PLANNING CONSULTATION RESPONSE

Application No	2026/0422
Proposal	Residential development of up to 144 units and associated works
Address	Land to the south of Weetshaw Lane Roundabout, Cudworth, Barnsley
Date of Consultation Reply	14 th August 2026
Consultee	Strategic Housing

APPENDIX B – Development Masterplan

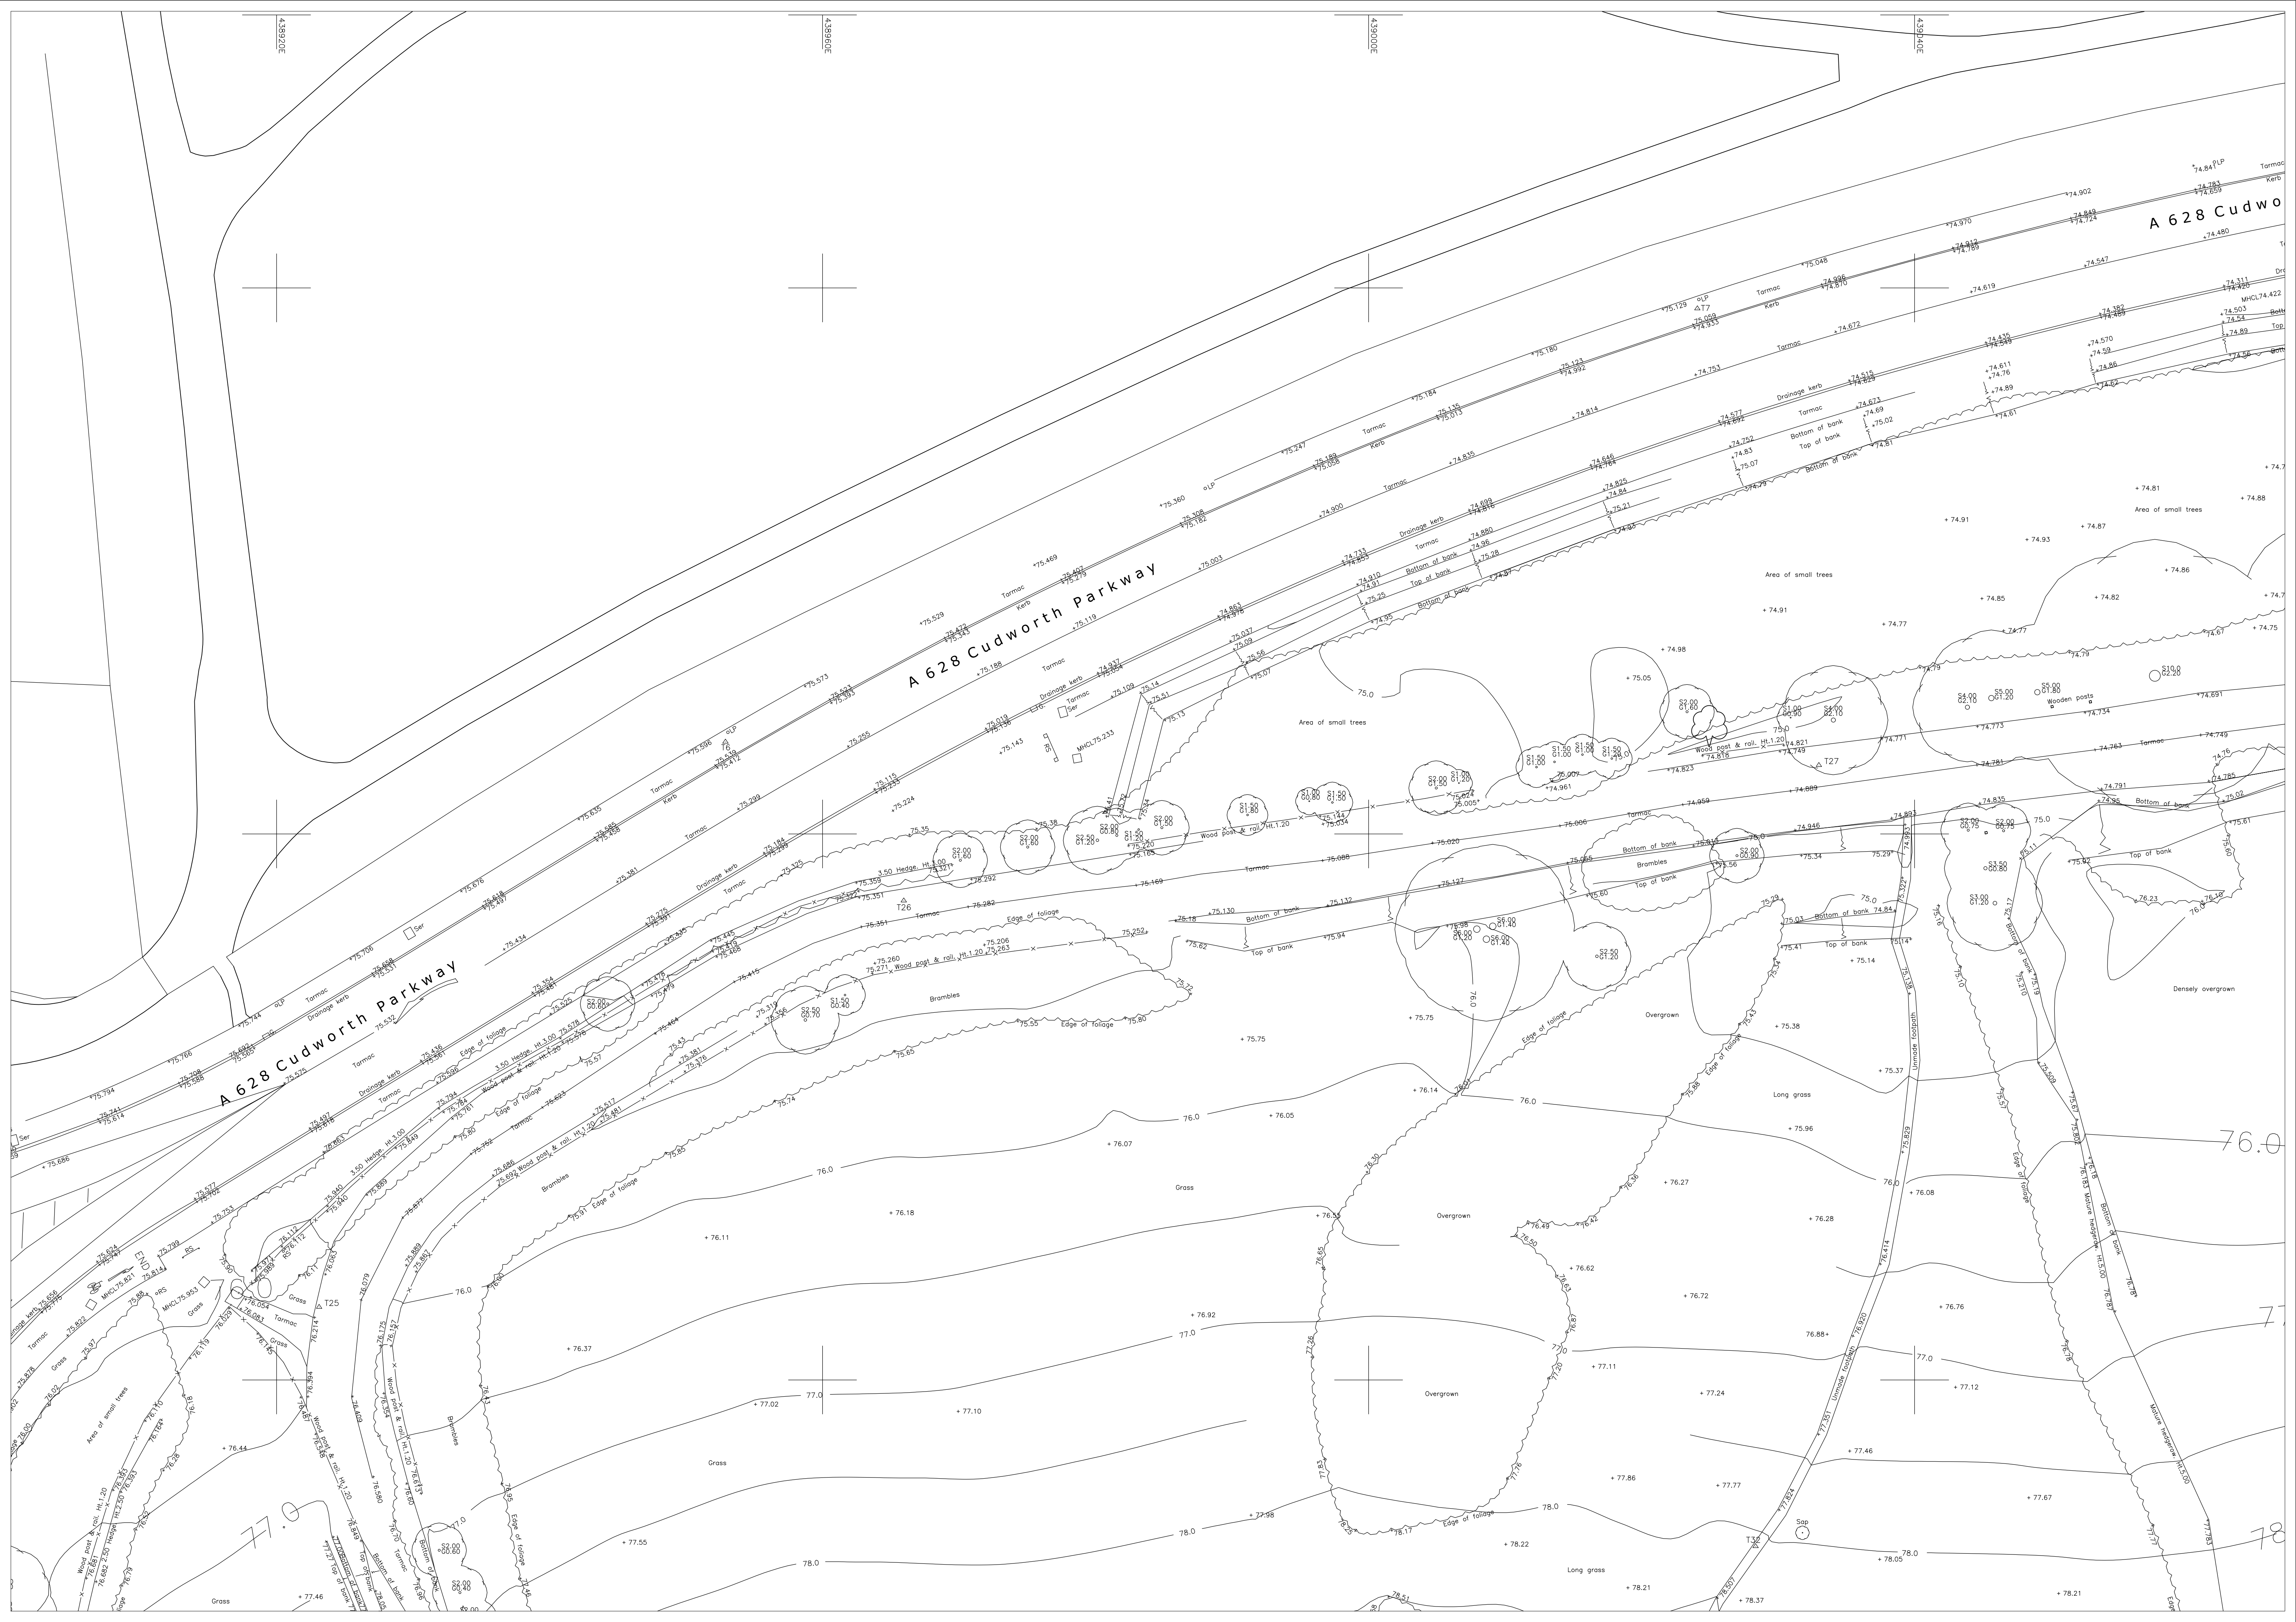
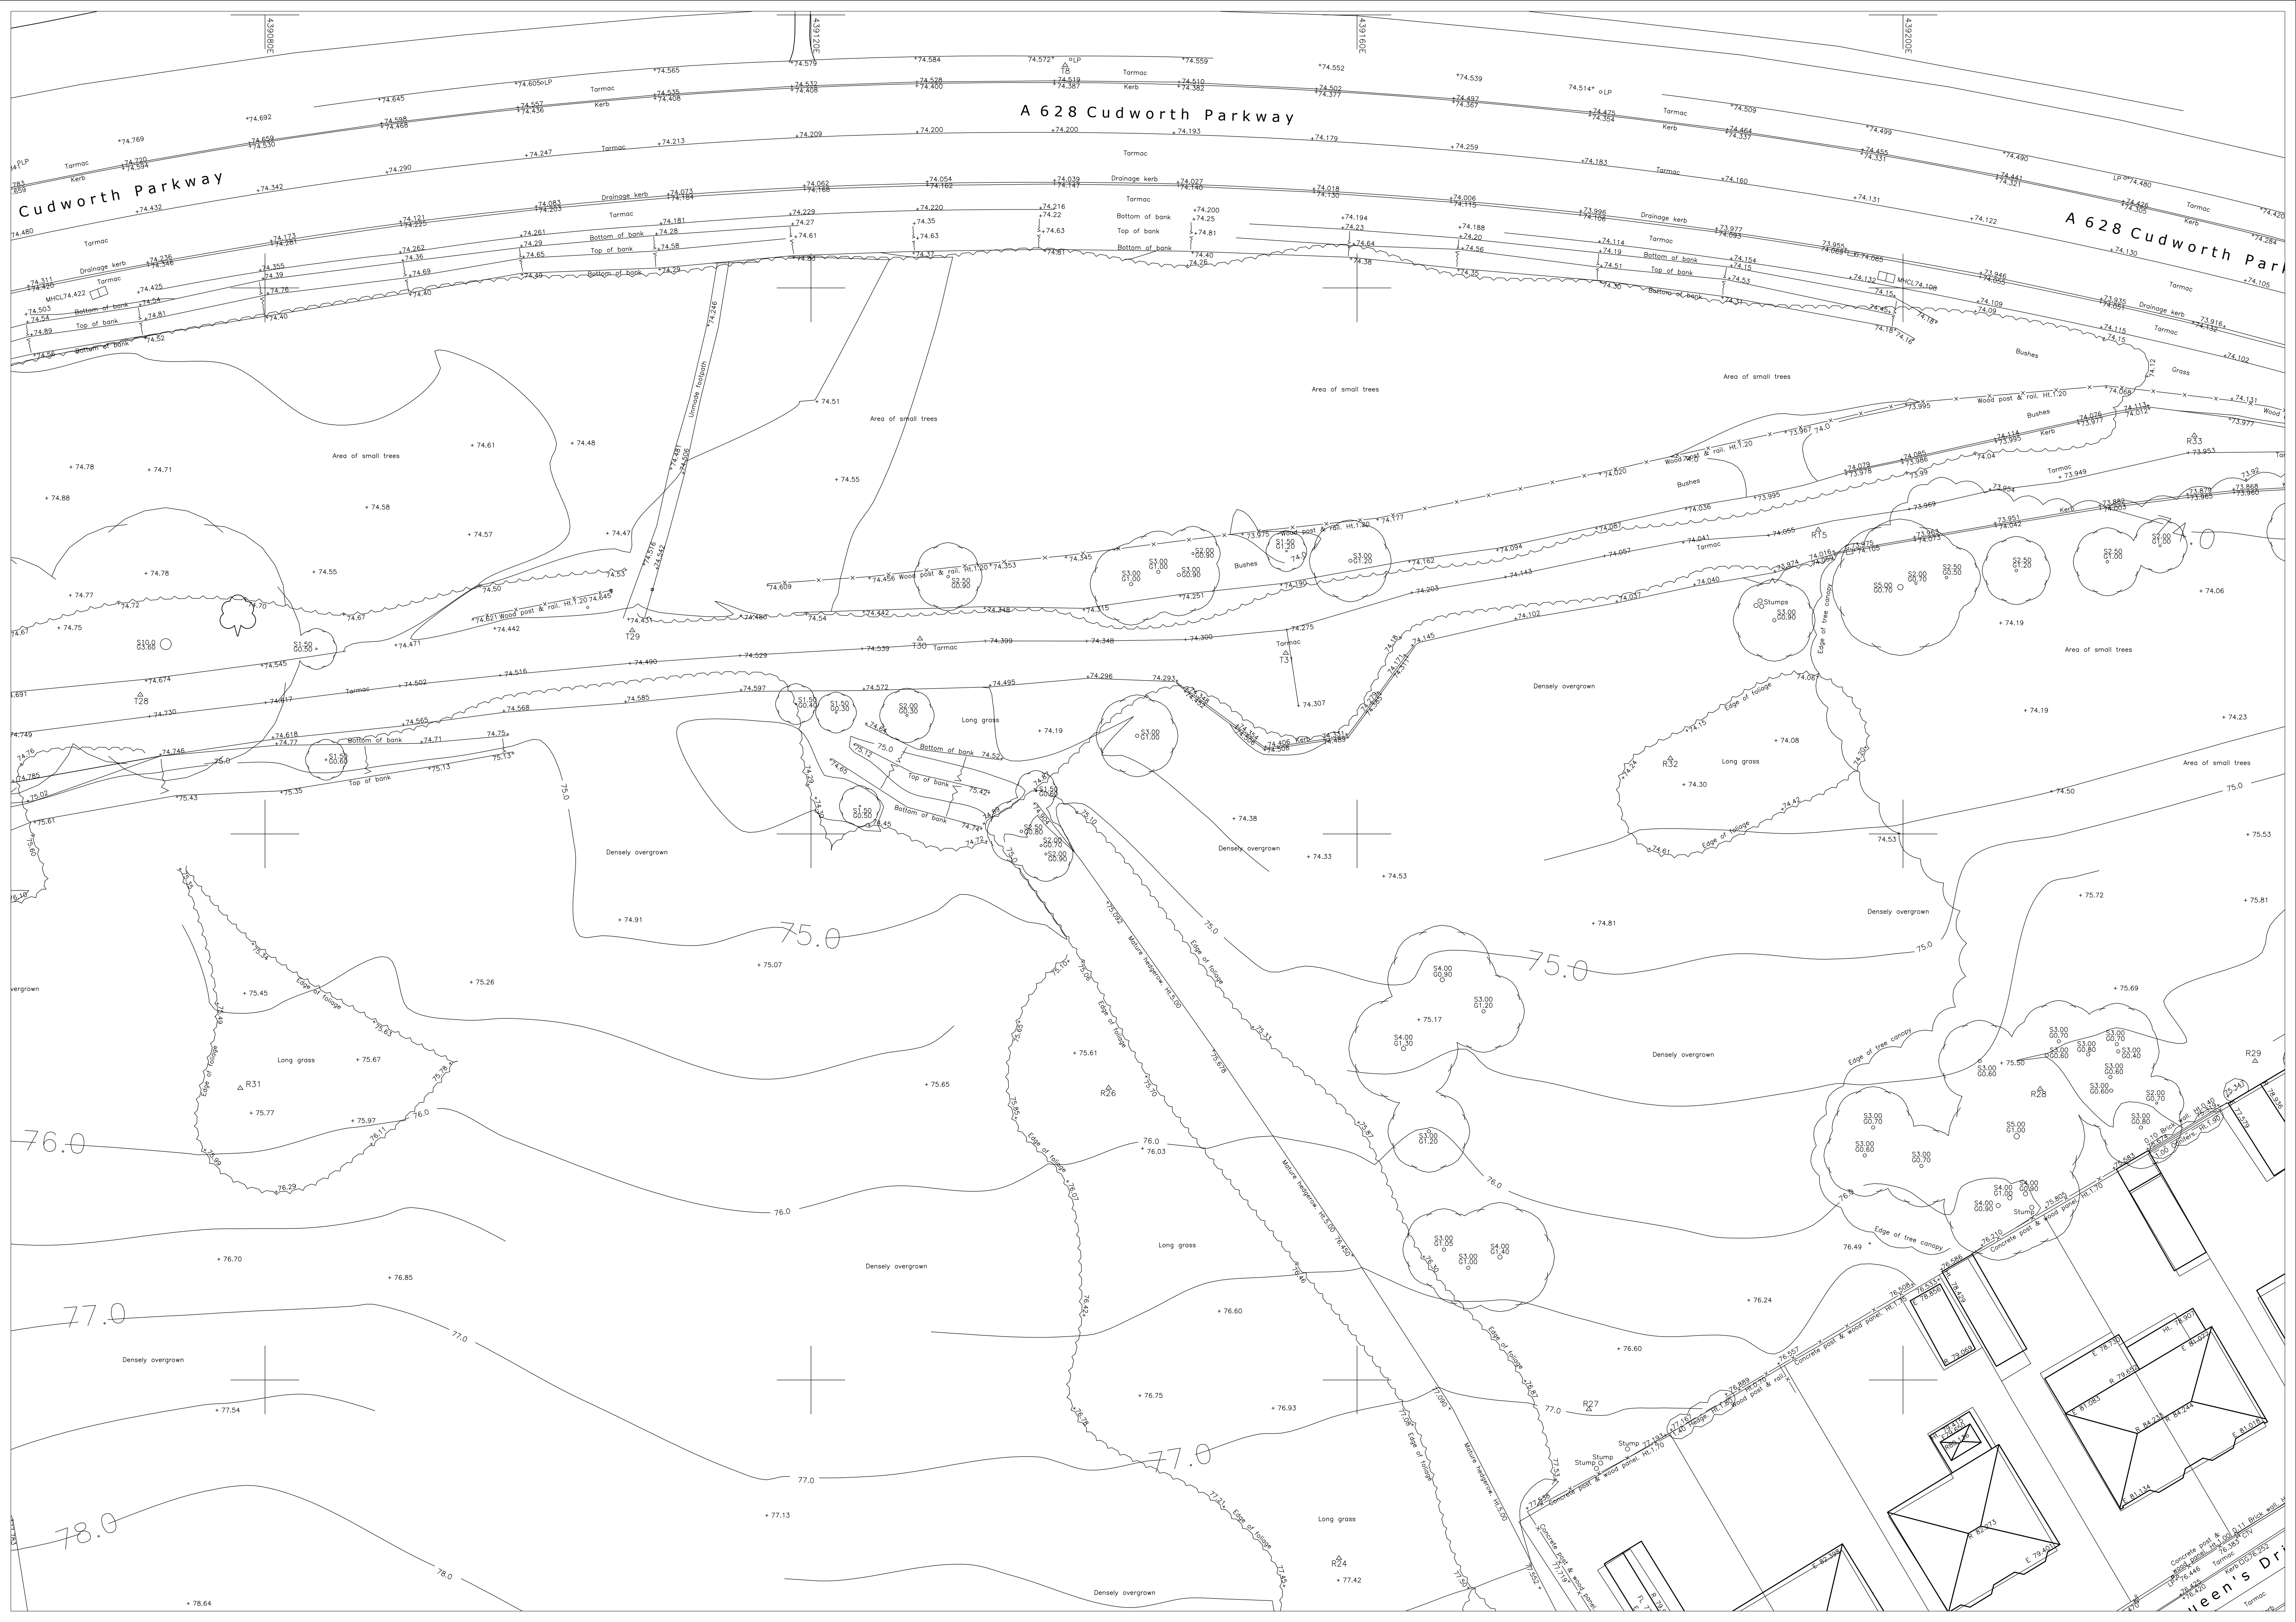
On the Proposed Site Plan, the affordable units are marked with a yellow dot. None of the four-bedroom dwellings (coloured green) are marked as affordable. The council would welcome the inclusion of 4-bed affordable units as there is a borough wide need for larger family accommodation for social and affordable rent.

The Proposed Site Plan does identify the affordable plots. These are dispersed across the larger section of the site, but the western area has no affordable plots.

The applicant should identify the accessible, affordable dwellings on the proposed site plan for ease of reference.

In response to the comments in the Property Type and Tenure sections, the applicant should review the location of the affordable units once their proposed mix of house types is confirmed. Consideration should also be given to including affordable units in the western section of the site.
